## EL PASO COUNTY GRADING AND EROSION CONTROL PLAN CHECKLIST

SHEET
CV

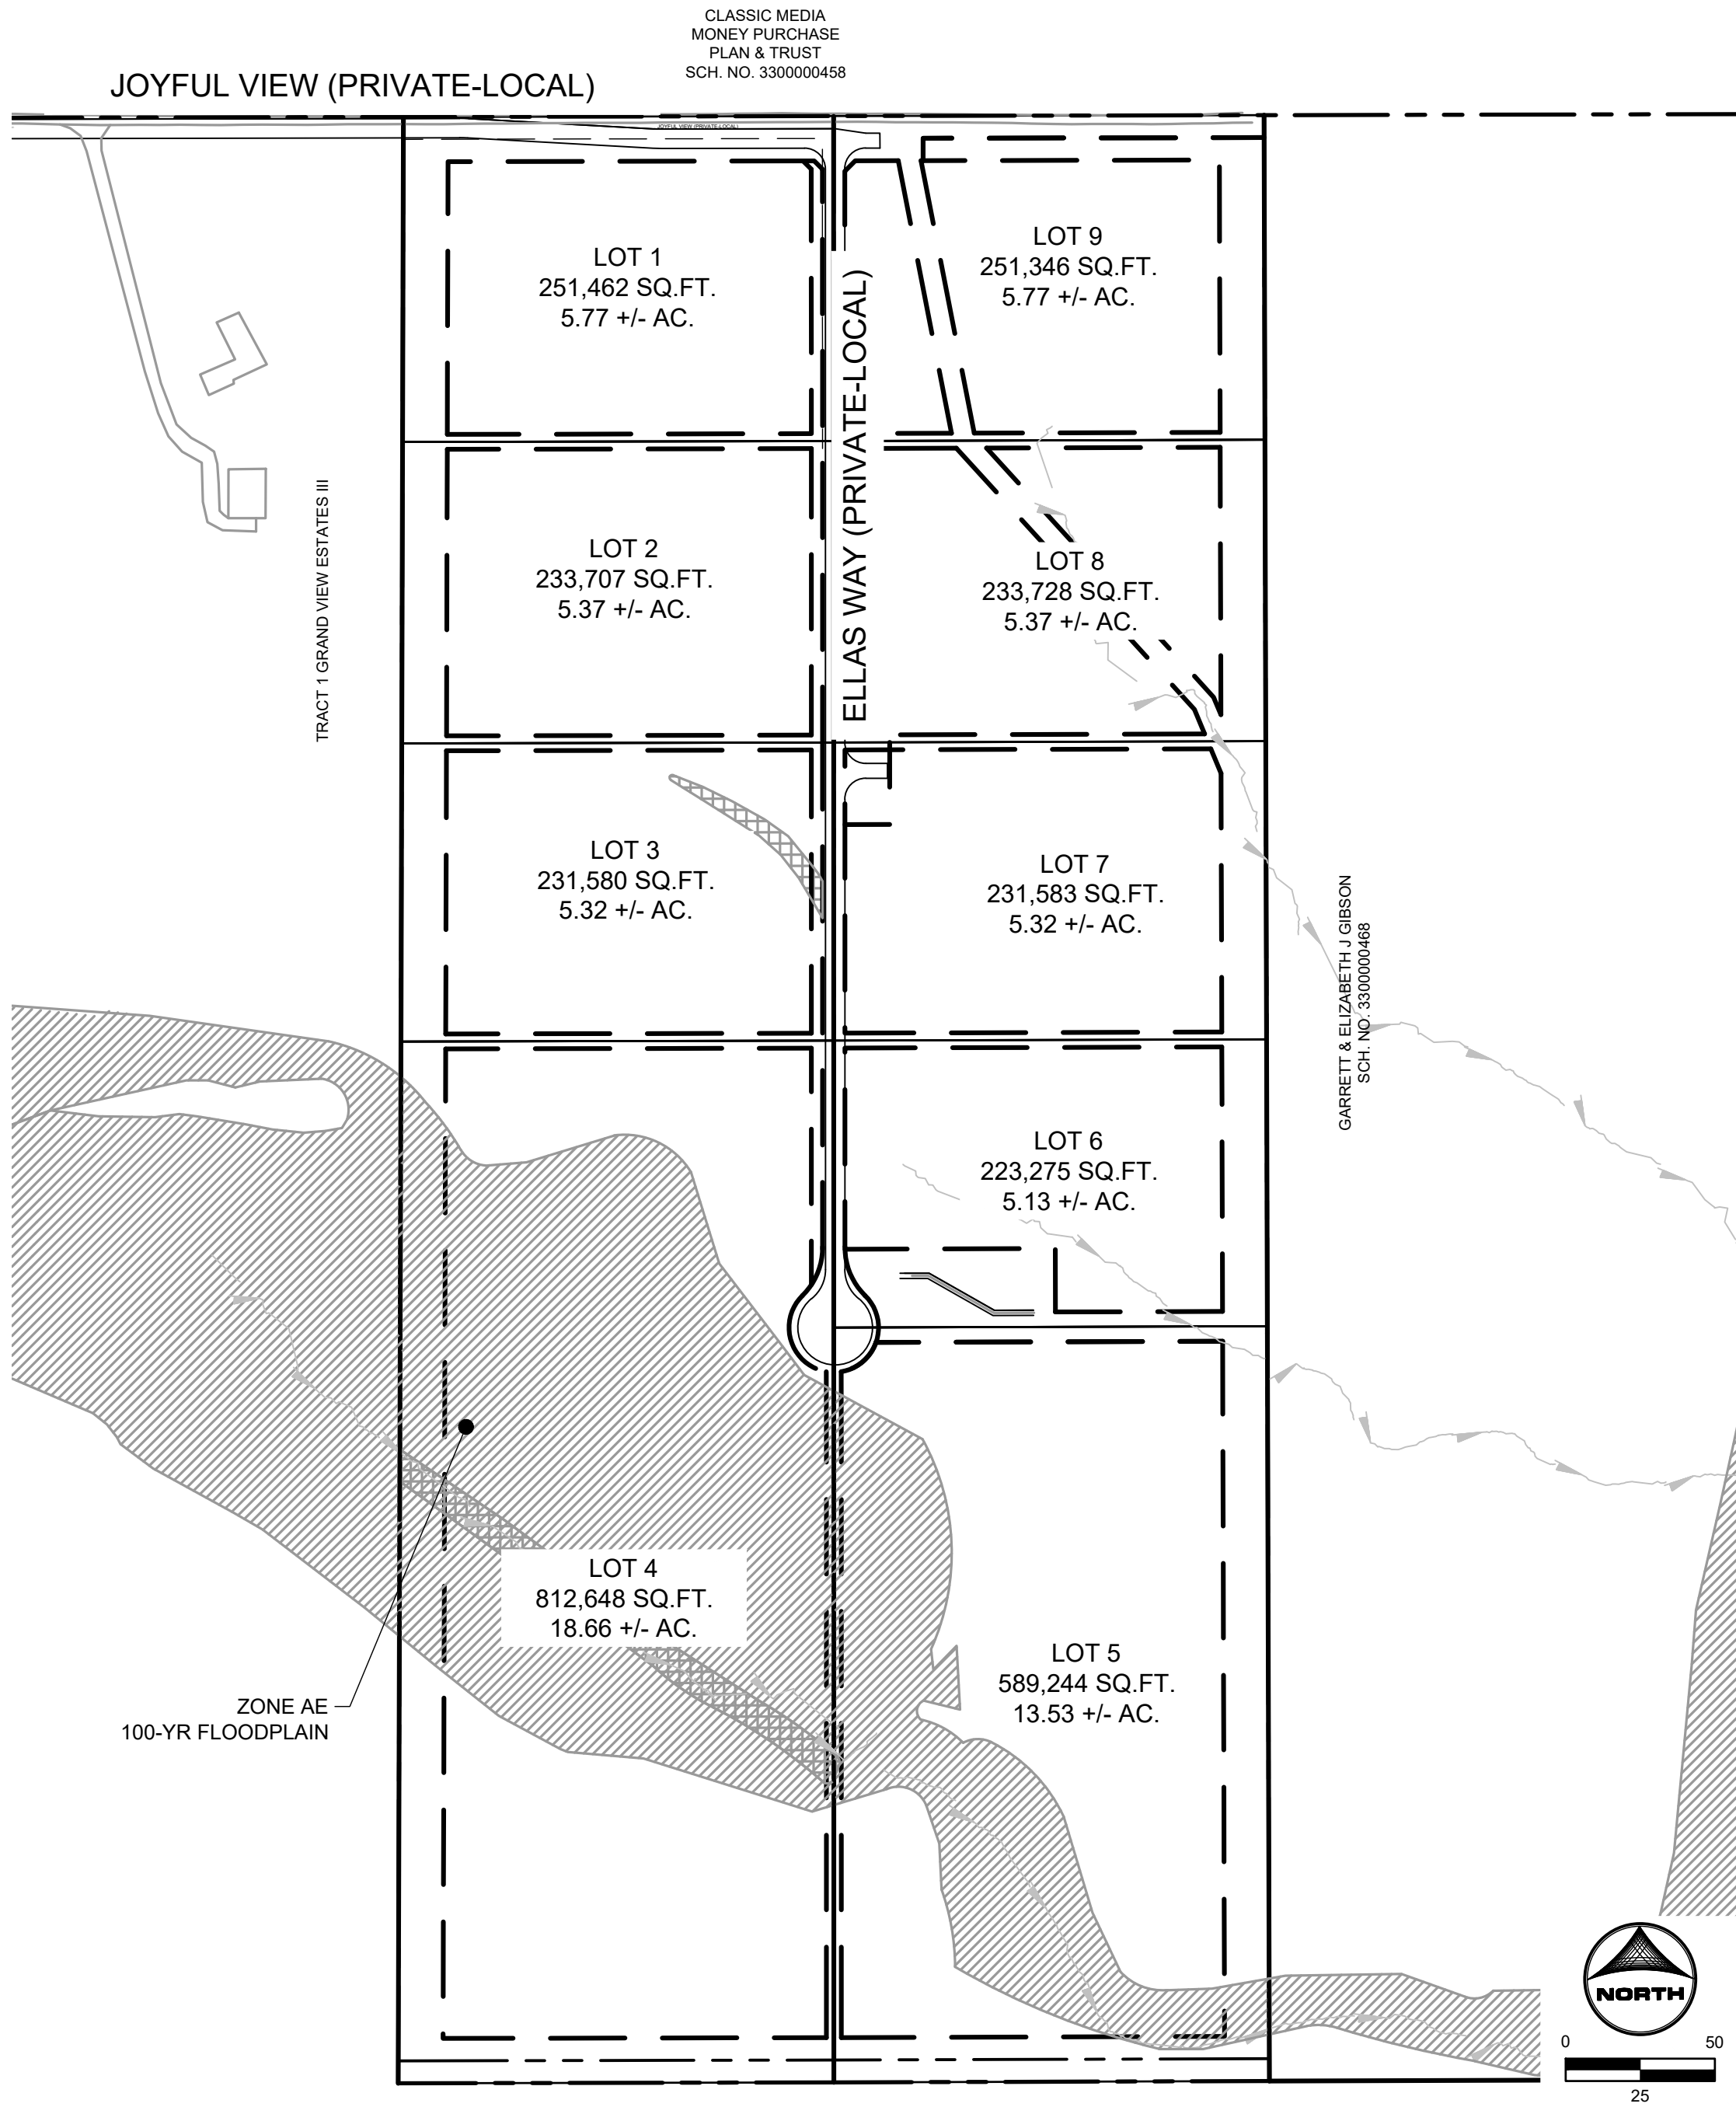
27	A water source shall be available on-site during earthwork operations and shall be utilized as required to minimize dust from earthwork equipment and wind.		Y
28	The soils report for this site has been prepared by <b>[Company Name, Date of Report]</b> and shall be considered a part of these plans.		N
29	<p>At least ten (10) days prior to the anticipated start of construction, for projects that will disturb one (1) acre or more, the owner or operator of construction activity shall submit a permit application for stormwater discharge to the Colorado Department of Public Health and Environment, Water Quality Division. The application contains certification of completion of a stormwater management plan (SWMP), of which this Grading and Erosion Control Plan may be a part. For information or application materials contact:</p> <p>Colorado Department of Public Health and Environment Water Quality Control Division WQCD – Permits 4300 Cherry Creek Drive South Denver, CO 80246-1530 Attn: Permits Unit</p>		Y

Included note 28.
